Consultation Response from KC, Highways Development Management (HDM)		
2024/91242 Land north east of Shepley Road, Stocksmoor, Huddersfield, HD4 6XW		
Erection of residential development (up to 50 dwellings) with associated access, parking, public open space, landscaping and infrastructure		
Date Responded: 11/04/25	Responding Officer: A.Darwin	Responding Ref: 12-33/18

RECOMMENDATION: HDM are unable to support the development proposals – see conclusion / recommendation at the end of this response.

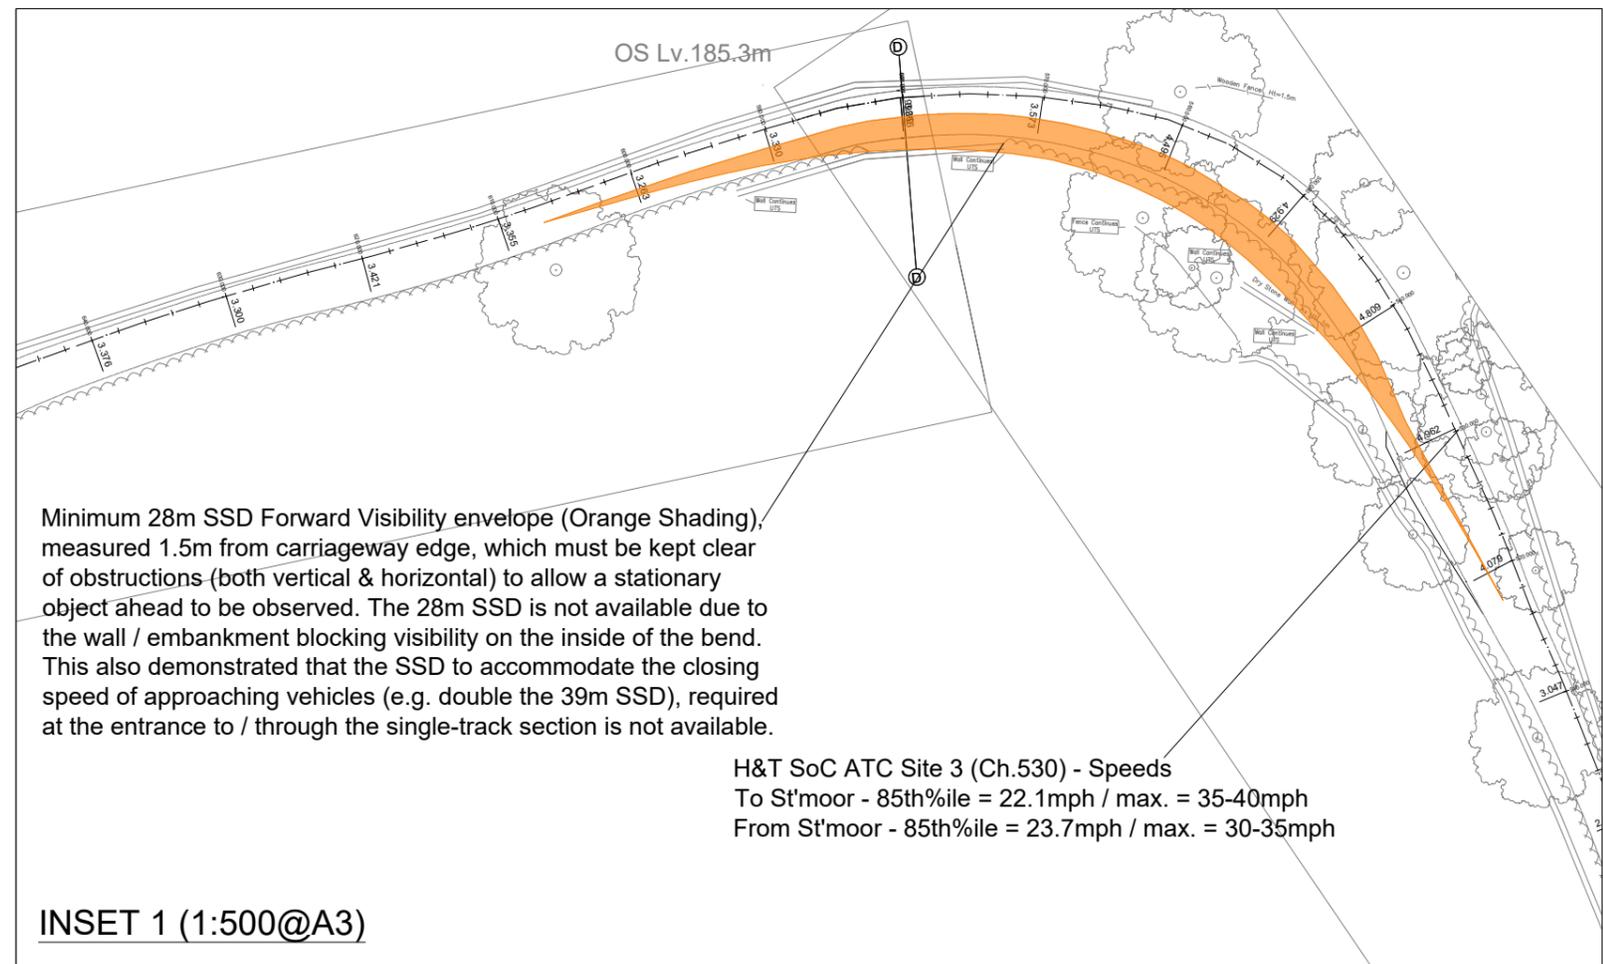
- Whilst some vegetation clearance has been noted on the plans, there are still a number of sections along the route where there would be inadequate inter-visibility between passing places, which cannot be improved due to the horizontal and vertical alignment of the highway, as well as vegetation and other features that are outside of the highway boundary that cannot readily altered.

- Even with the improvements, there would still be a number of sections of Stone Wood Lane where the spacing of passing places (for cars/vans) is well beyond the recommended maximum distance of 60m,

- A 140m+ length between ch.700-560, which also has restricted forward visibility due to bends and a steep gradient;
- A 60m+ length between ch. 520-460, which also has restricted visibility due to a bend and the vertical alignment of the carriageway;
- A 100m+ length between ch.440-340, which also has restricted forward visibility due to bends;
- A 70m length between ch.300-230, which also has restricted forward visibility due to bends;
- A 100m+ length between ch.120-20;
- For a 500m section of Stone Wood Lane between ch. 20 to 520, the carriageway width is generally between 2.6-3.5m wide (except at the passing places), which is below the width where a car/van can safely pass a pedestrian or cyclists, as acknowledged in the TAA report.
